Tel: 01903 737756
Email: planning@arun.gov.uk
www.arun.gov.uk/planning
Please ask for: Amy Anderson
Email: amy.anderson@terraquest.co.uk
Telephone: 0121 234 1390
Our Ref: A/186/25/HH
Your Ref:
Date: 17th December 2025

Application for Planning Permission for Works or Extension to a Dwelling

Development: Conversion of garage into habitable space and alterations to fenestration.
Location: 16 Speedwell Chase Angmering BN16 4QR

Rev.	Notes	Date
 M: 07599199759 E: info@nat-design.co.uk www.nat-design.co.uk		
Project		
16 Speedwell Chase, Angmering, BN16 4QR		
Drawing		
Existing & Proposed Floor Plans		
Drawn By		Scale
NSE		as shown
Date		Revision
Nov 2025		
Drawing No.		
2018 - DPA - 03

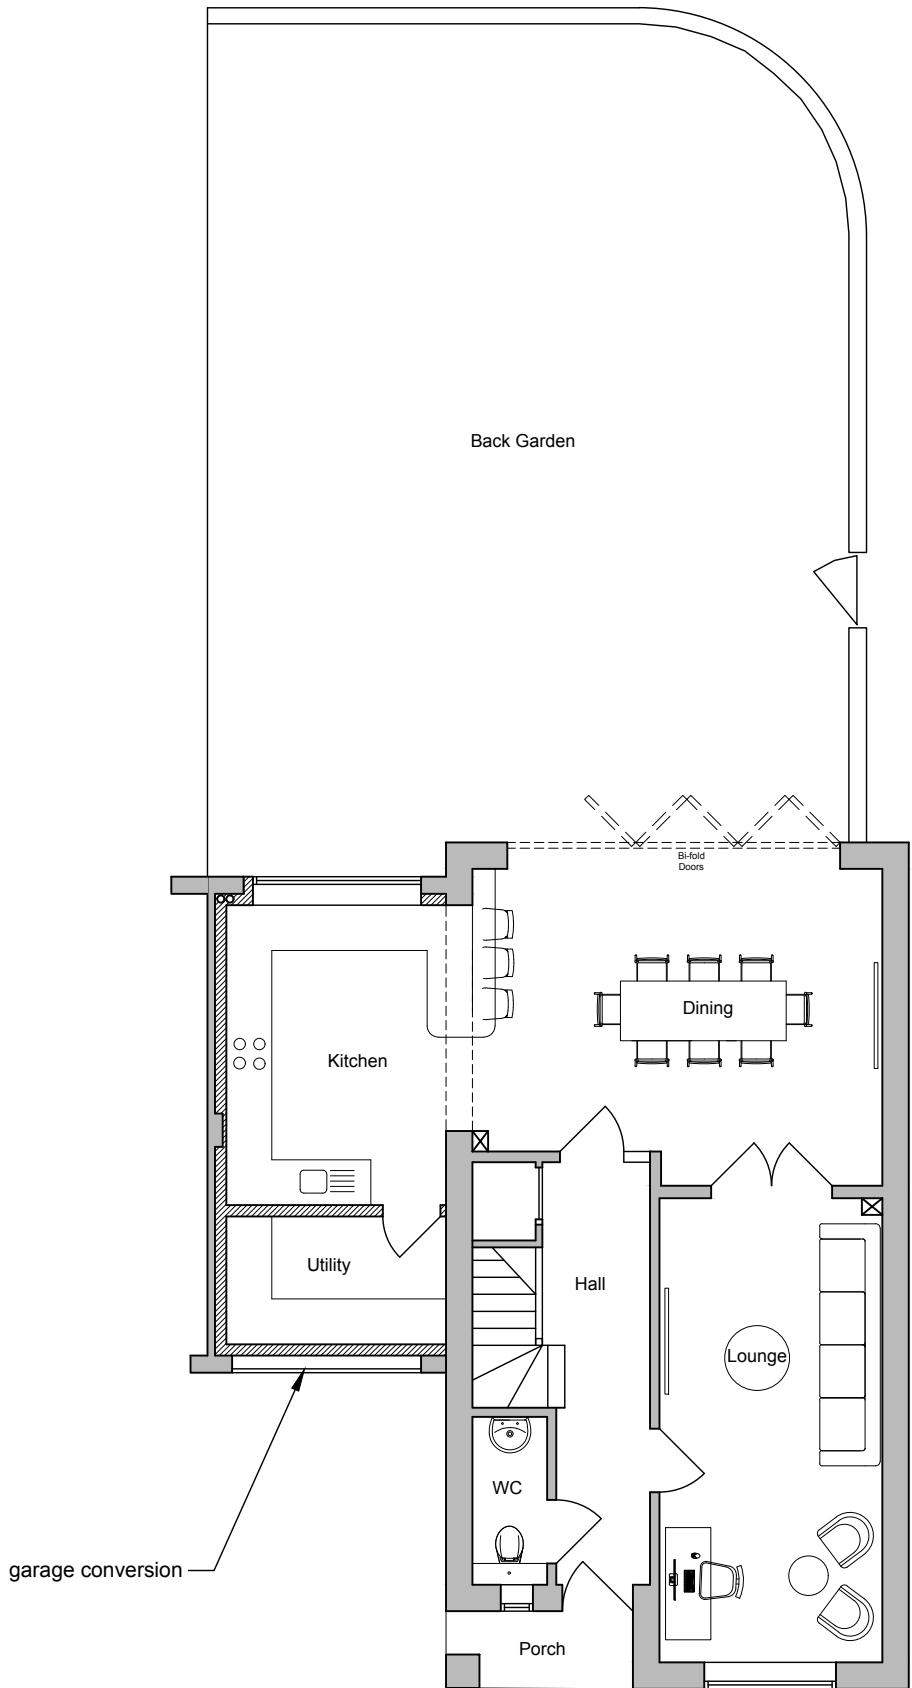
The proposed front elevation states 'no changes' however the proposed floor plan shows the garage door converted into a window. Please confirm which one of these is correct by amending the plans to be consistent.
